2000-3 Arapaho Road

Change Orders - 2001

CHANGE ORDER NUMBER 9

Project: Arapaho Road Improvements Phase I

STRIPING PLAN
STA 88+00 TO 96+00
ARAPAHO ROAD
ADDISON ROAD TO DALLAS NORTH TOLLWAY
TOWN OF ADDISON, TEXAS

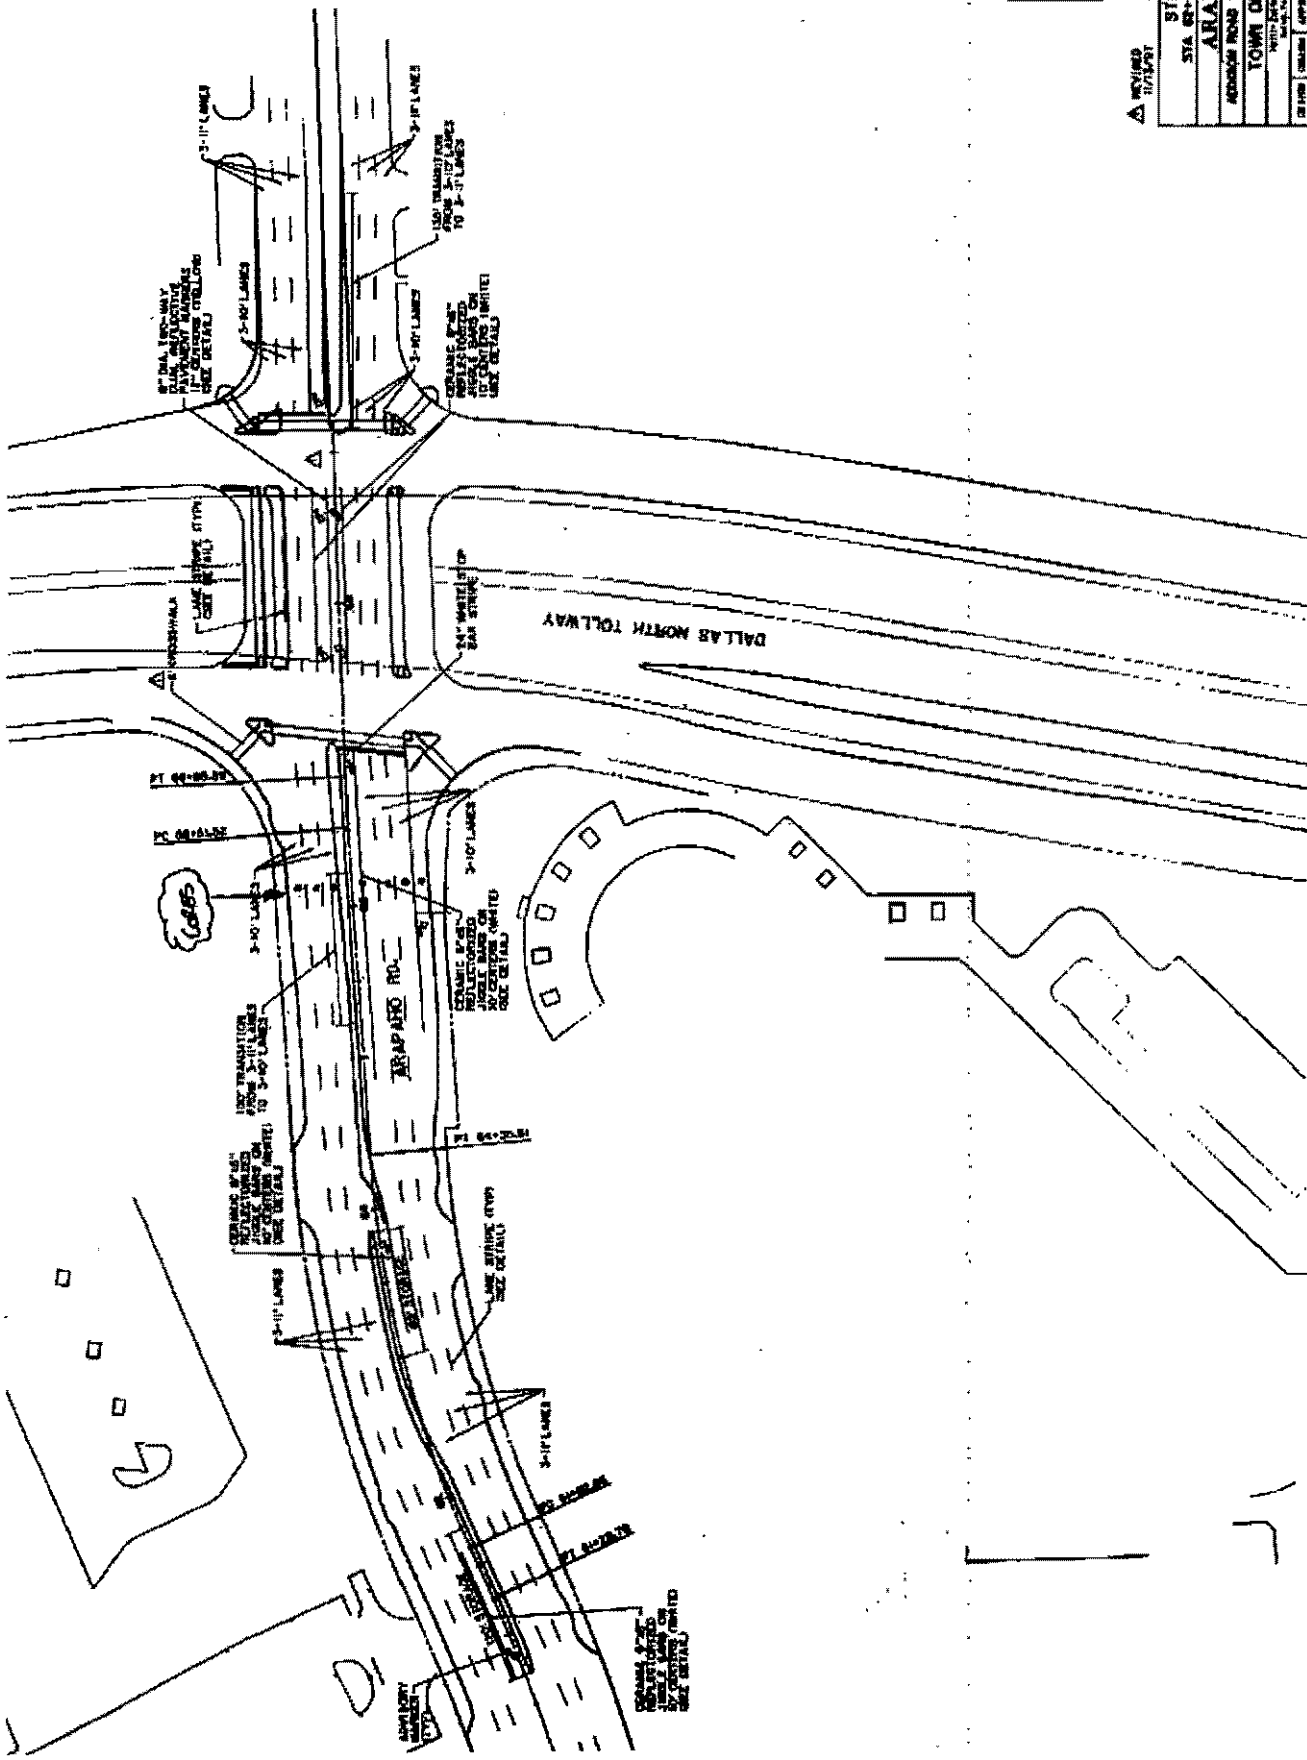
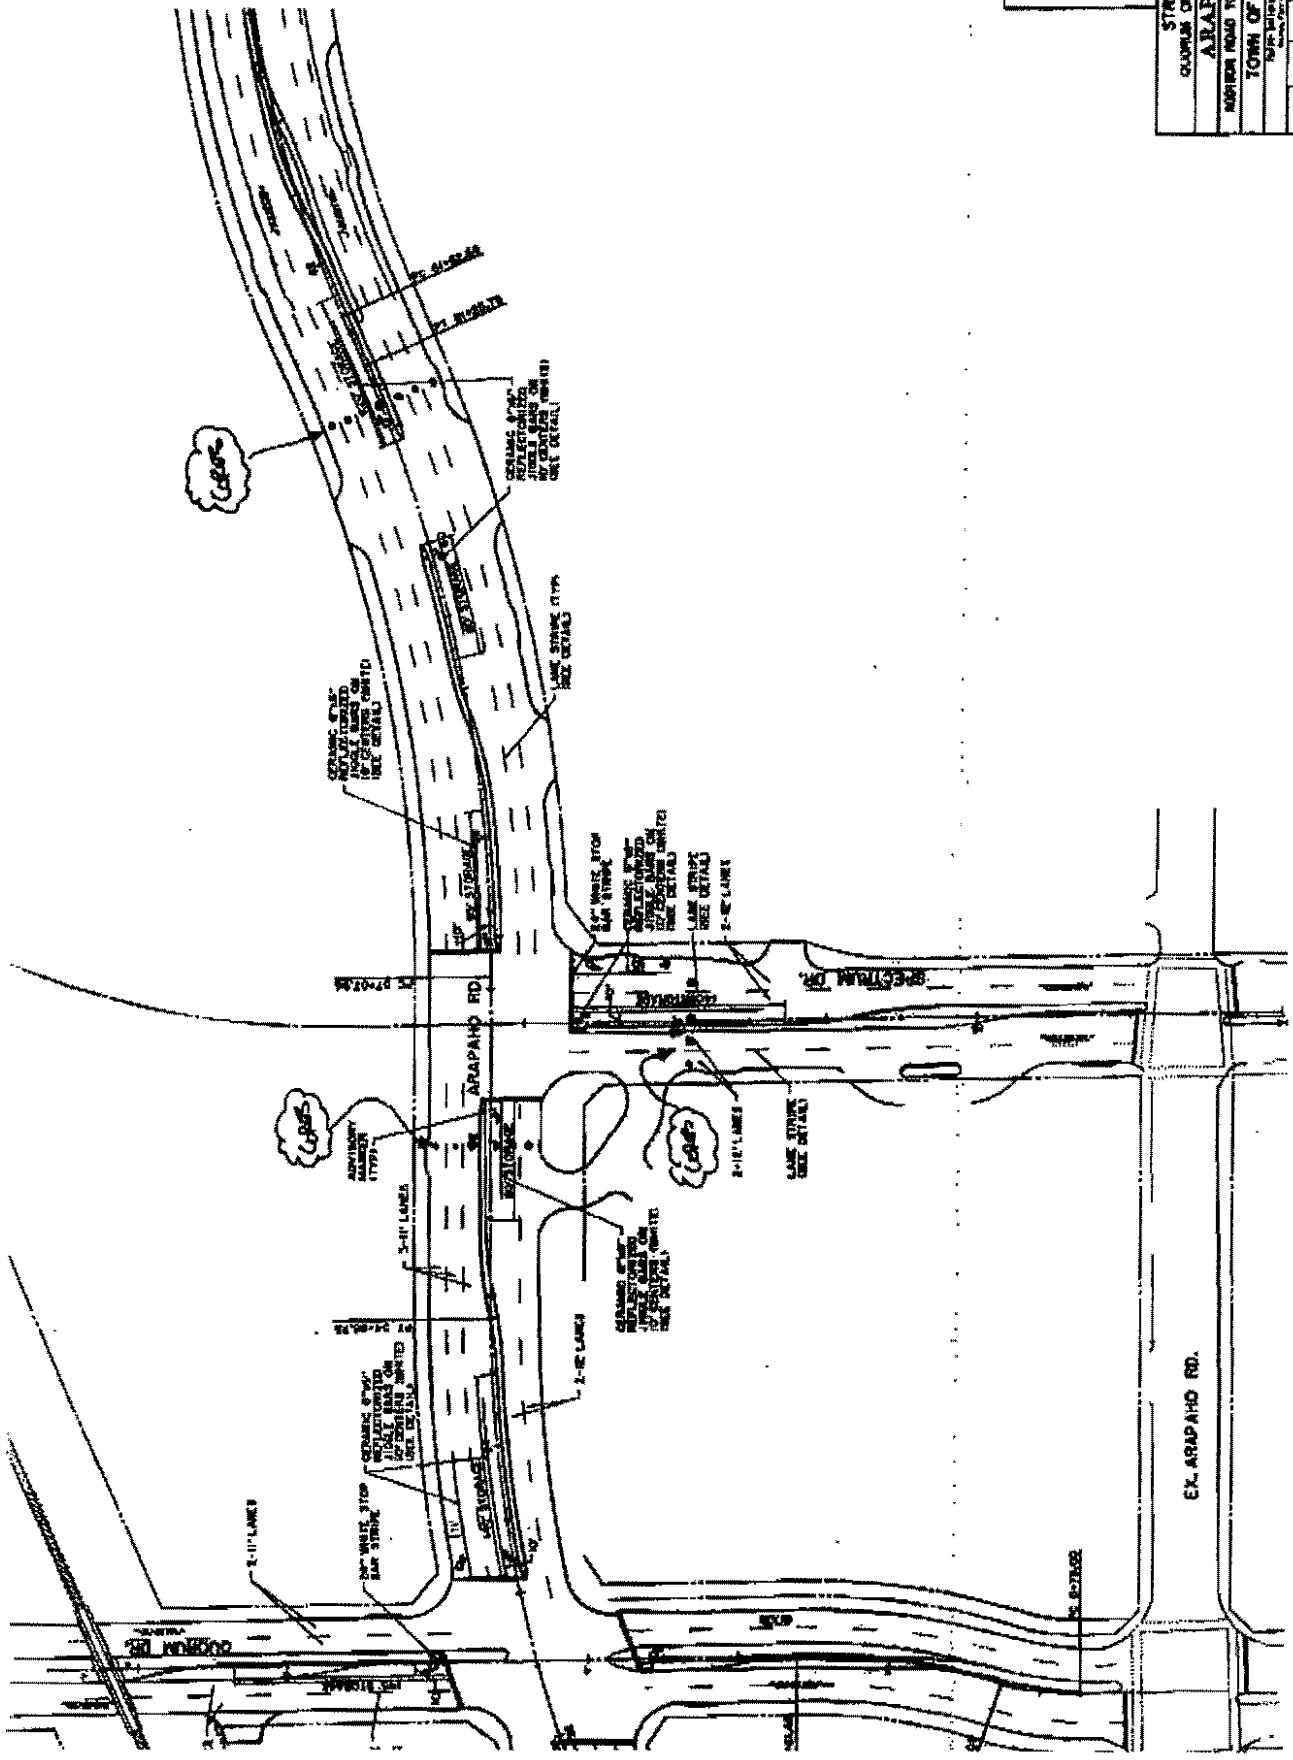
Description: Striping Changes at Dallas Parkway:

Elim Exist 24" Stripe	98 LF @ \$3.45 = \$338.10
Elim Exist Arrows	8 EA @ \$35.00 = \$280.00
Elim Exist 6" Stripe	487 LF @ \$1.15 = \$560.05
Add 8" Thermo Stripe	826 LF @ \$2.50 = \$2,065.00
Add 4" Thermo Stripe	278 LF @ \$1.25 = \$347.50
Total This Item	\$3,590.65
